**From:** [Mole Valley Cycling Forum](#)  
**To:** [REDACTED]; [Gatwick Airport](#)  
**Subject:** Gatwick Airport DCO  
**Date:** 26 February 2025 14:52:20

**Interested Party Reference number: 20044002**

Mole Valley Cycling Forum (MVCF) responded to the DCO and attended the Issue Specific Comments on Surface Transport (Walking and Cycling). MVCF continues to object to this application, and wishes to reiterate the following points should the application be granted:

FIGURE 12.6.2

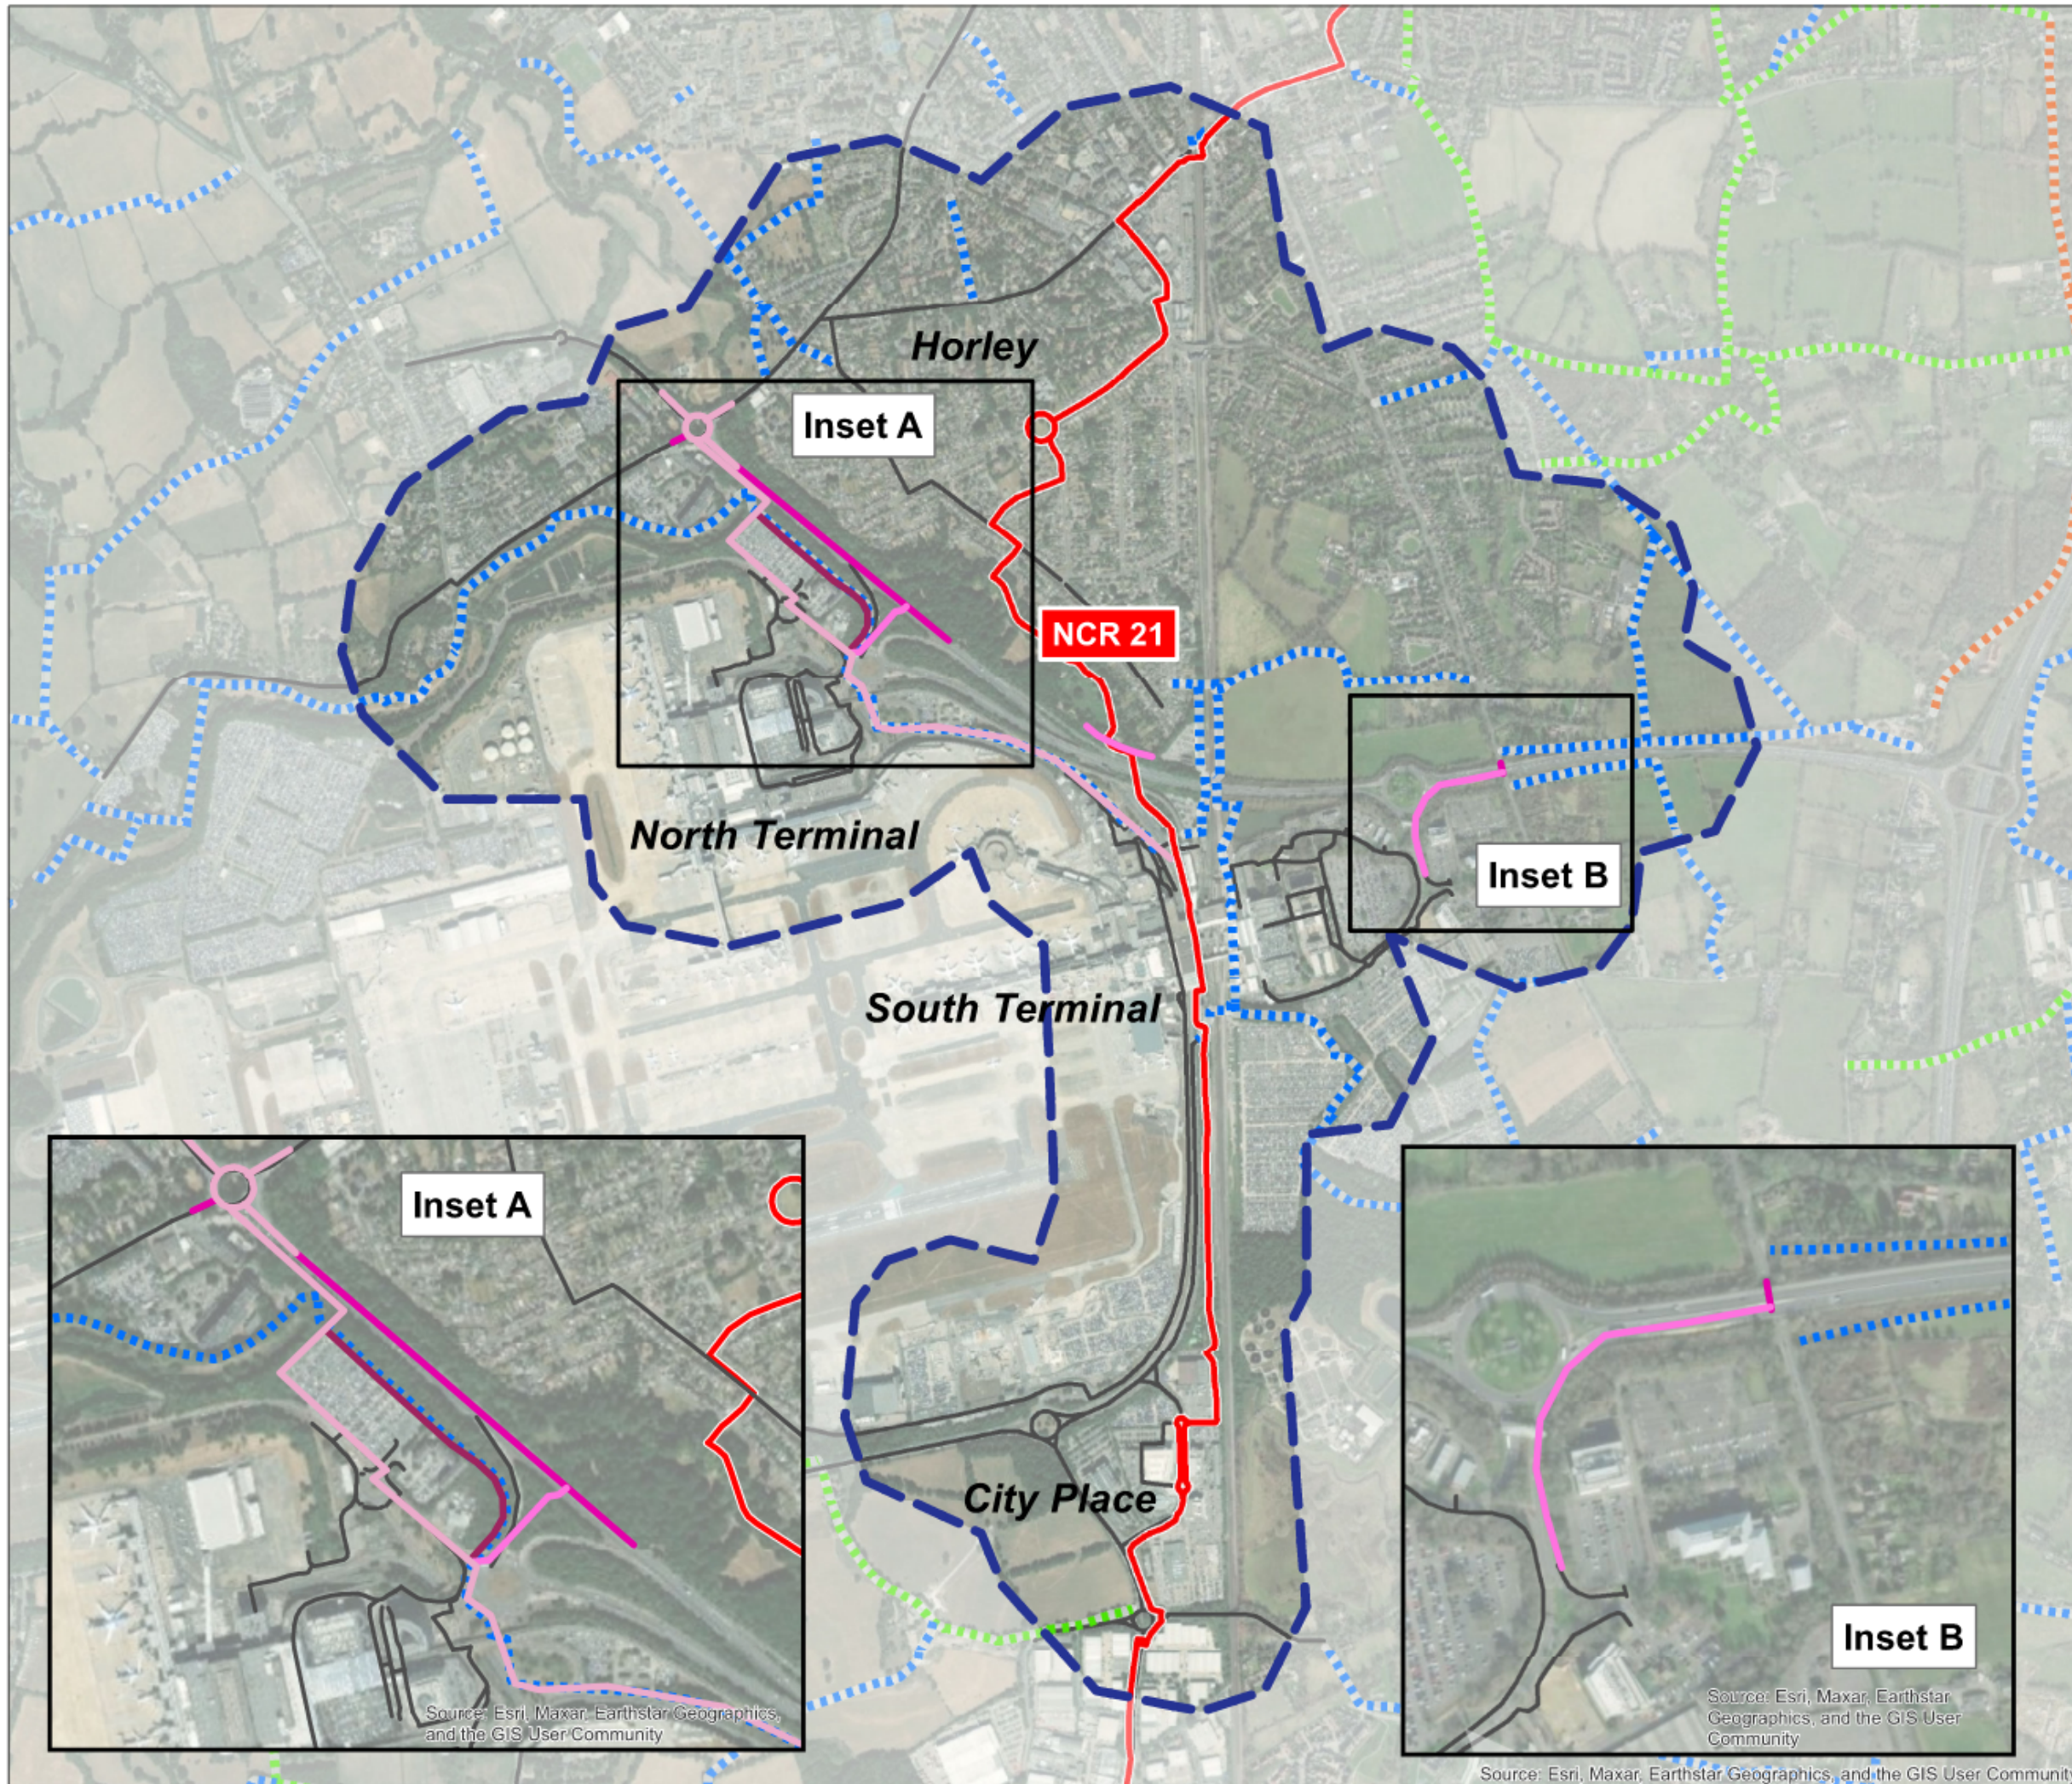
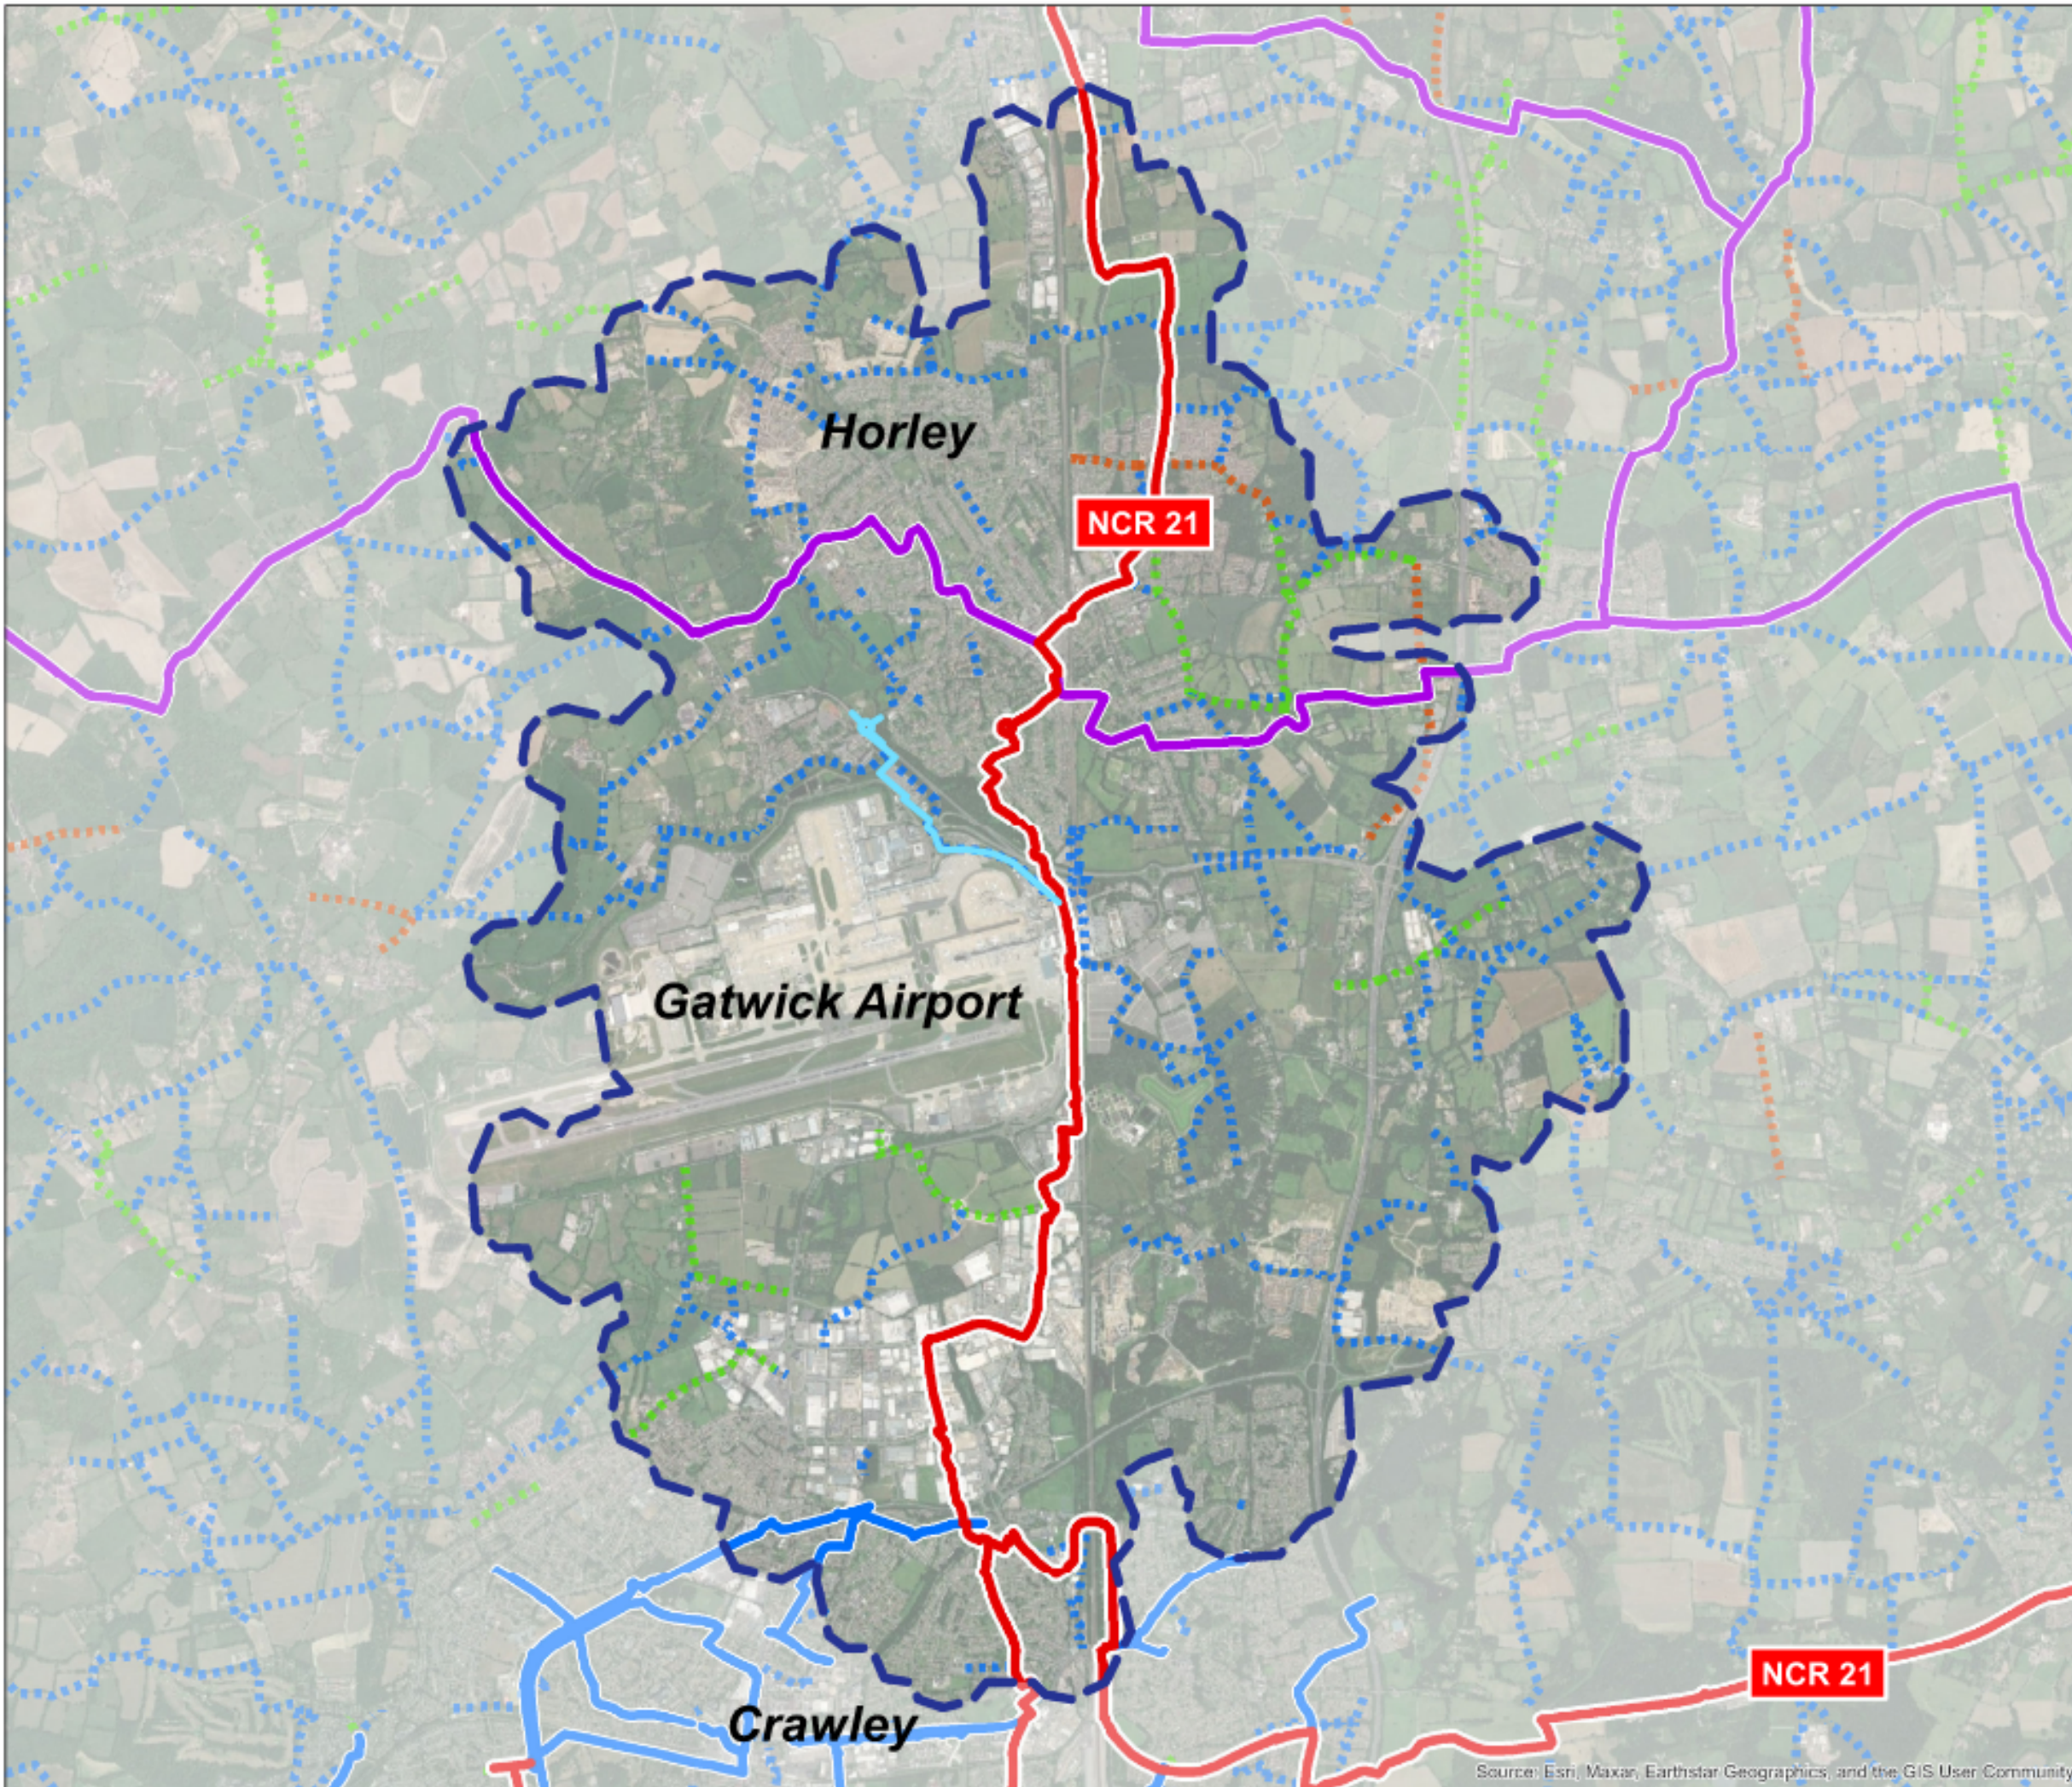
We also note with concern that the National Cycle Network Route 21 (which forms part of the Avenue Verte from London to Paris) and which passes through the airport from Horley to Crawley, has been omitted from all the maps provided and we hope that in your review, you have considered its presence.
